Awel y Môr Offshore Wind Farm

Comments on Land Use Consultants' Review of LVIA and SLVIA

Deadline 2

Date: 09 November 2022

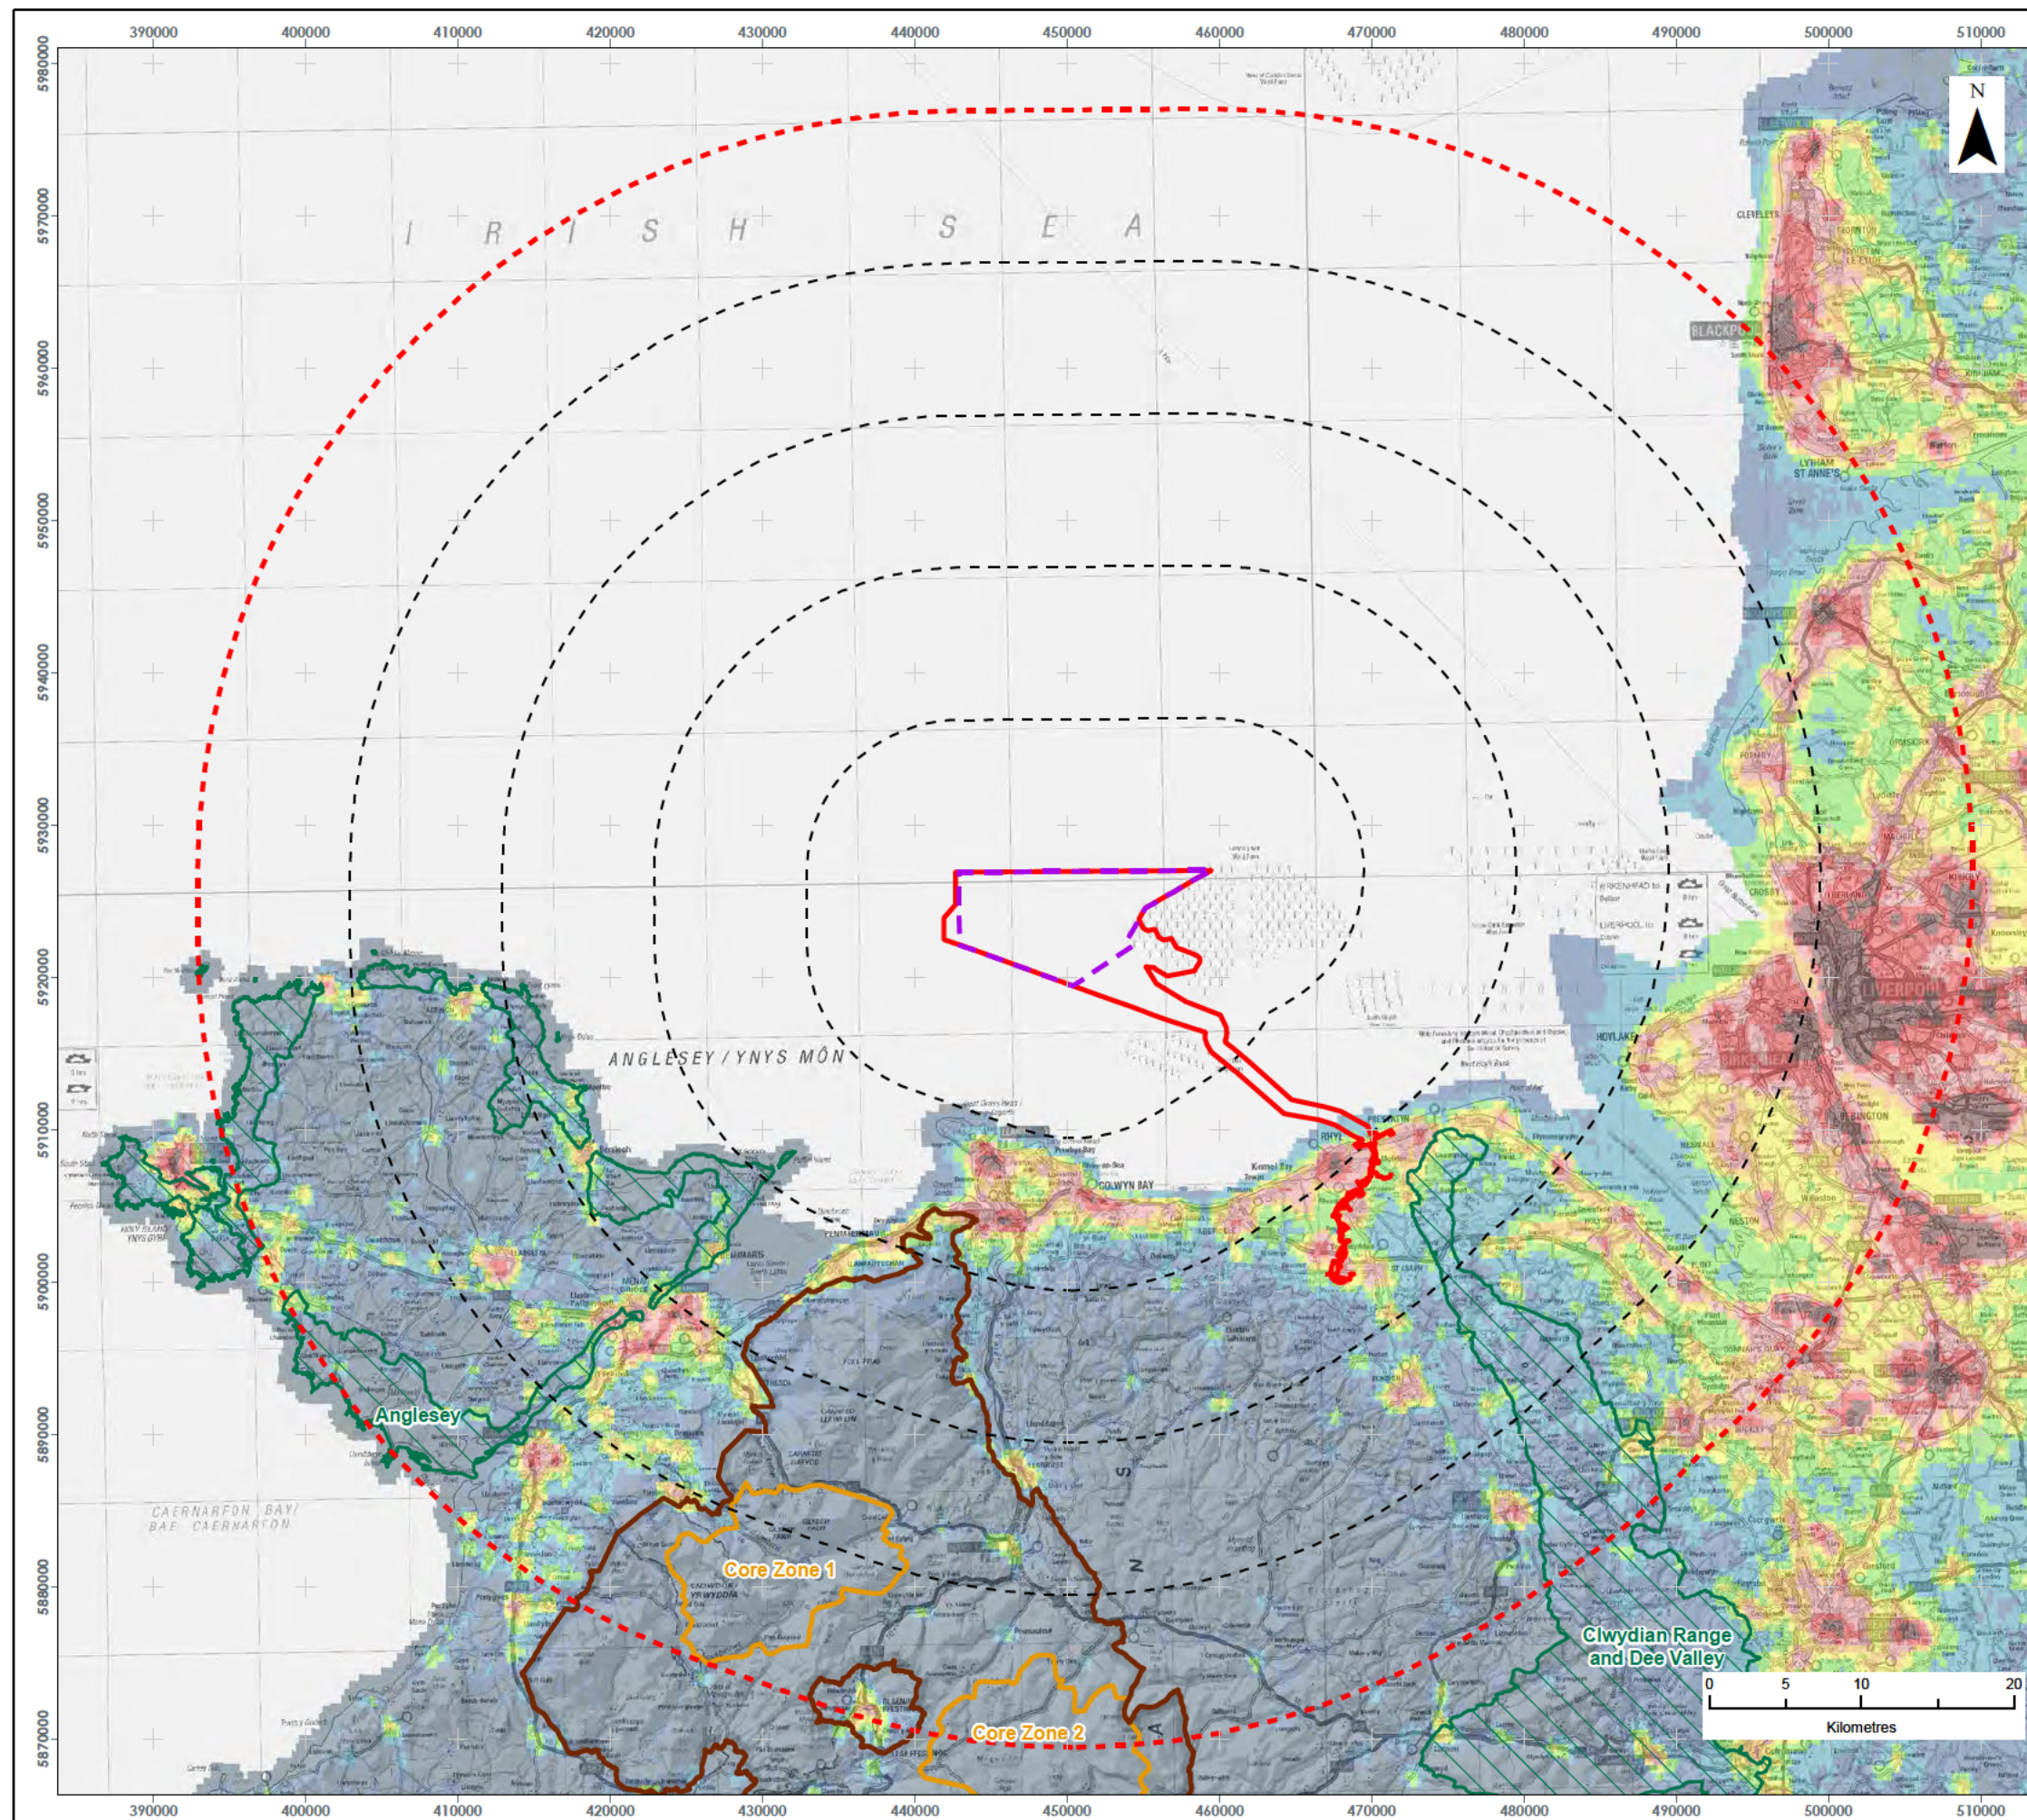
<p>Across Gwynedd, with reference to:</p> <ul style="list-style-type: none"> ▲ Figure 10a – Baseline Light Pollution; ▲ Figures 21a-c – Hub Height Aviation Lighting ZTV (MDS A); and 	Non-significant	Agreed: the SLVIA assesses non-significant effects "at locations within Gwynedd, largely as a result of the baseline light influence within and around the coastal edge and around Conwy Bay".	Minor (non-significant)	Agreed	No comment received	Agreement noted
